RE: 39 Mayfield Street

Please find response to your comments for the Single Family Site Plan at 39 Mayfield Street. The surveyor for this project is James Mullen, PLS of Spurwink Survey. Please find updated plans from him and Northeast Civil Solutions enclosed.

SITE PLAN

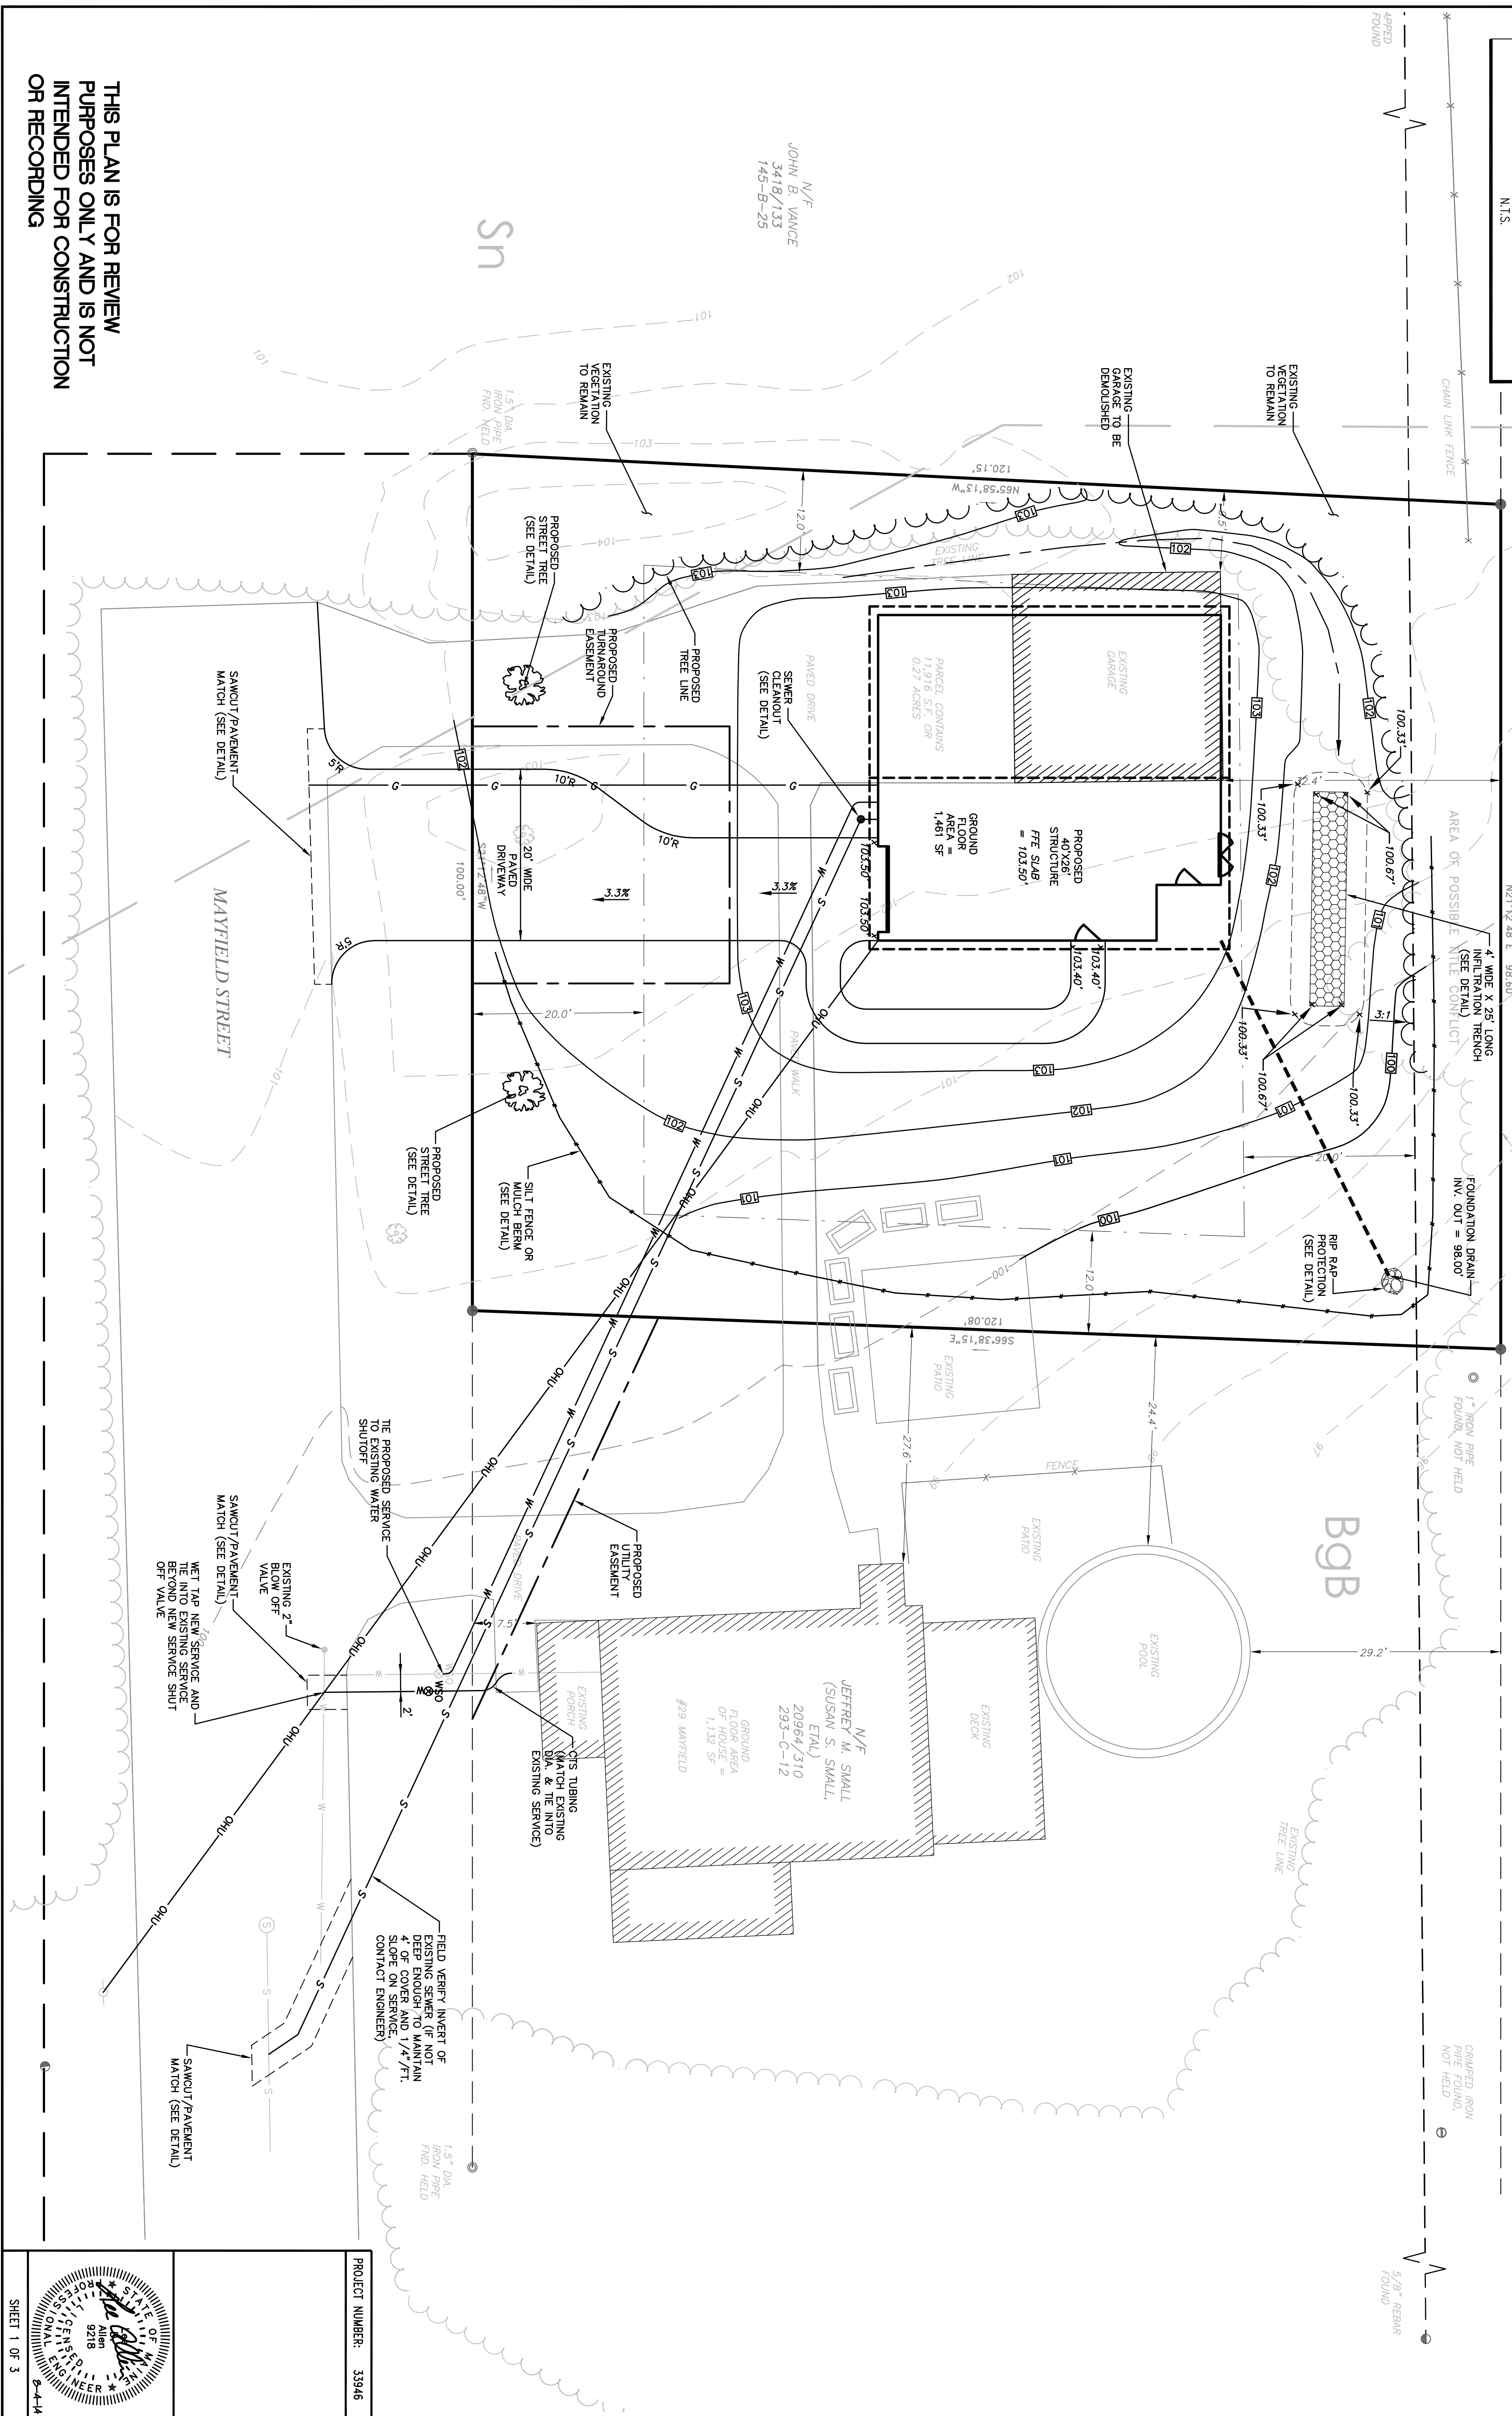
- Please show existing and proposed structures and the distance from all property lines. **All dimensions to existing and proposed structures were added to the plan.**

- Please add ground floor area. **The ground floor area has been added to each plan.**
- Please add soil type to the plan. **The soil types from NRCS were added to the plan.**

- Please show on the plan the existing vegetation that is to be preserved in compliance with section 14-526(b)2a, Environmental Quality Standard, of the Site Plan Ordinance. **All existing vegetation to be saved has been labeled on the plan.**

- Please add to the site plan, the required 2 street trees along the street frontage, meeting the City's minimum arboricultural standards. **Two street trees and planting detail has been added to the plan.**

- Please add to the Site Plan, area in square feet of the proposed site disturbance. **Note #12 on the Site Plan has been added indicating the area of site disturbance.**

- Please add turnaround consistent with City Design Guidelines and Technical Standards. The turnaround should be located along and connected to the northern edge of the driveway entrance. As was discussed during our telephone

- Please submit the proposed easement for the utilities that cross the abutting lot. **The utility easement has been modified that crosses 29 Mayfield Street and has been indicated on the Site Plan.**

- The building footprint on the Site Plan needs to match the footprint on the architectural plan. **The site plan was updated to match the architectural drawings.**

- Please add the exact square footage of the lot to the site plan. **Exact lot area was added to the plan.**
- According to the following deeds, book 14443, page 170 and book 20964, page 310, assessing lots 293 C012 (29 Mayfield Street) and 145 B032 are all one lot owned by Jeffery Small, Susan Small and Ellen R Stanley. With the demolition of the garage that was accessory to the house at 29 Mayfield Street and the new single family home being built, CBL Lot 145 B032, will be a separate lot with a single family home. This lot will need to have a separate deed recorded at the registry of deeds. **Once the lot is split and approved a new deed will be filed.**

- Since this new single family home lot is being split from 29 Mayfield Street, the site plan and survey needs to show all of the existing house lot at 29 Mayfield Street. The grading plan that was submitted as the site plan only shows a partial section of the existing house lot. **All existing features at 29 Mayfield were added to the plan.**
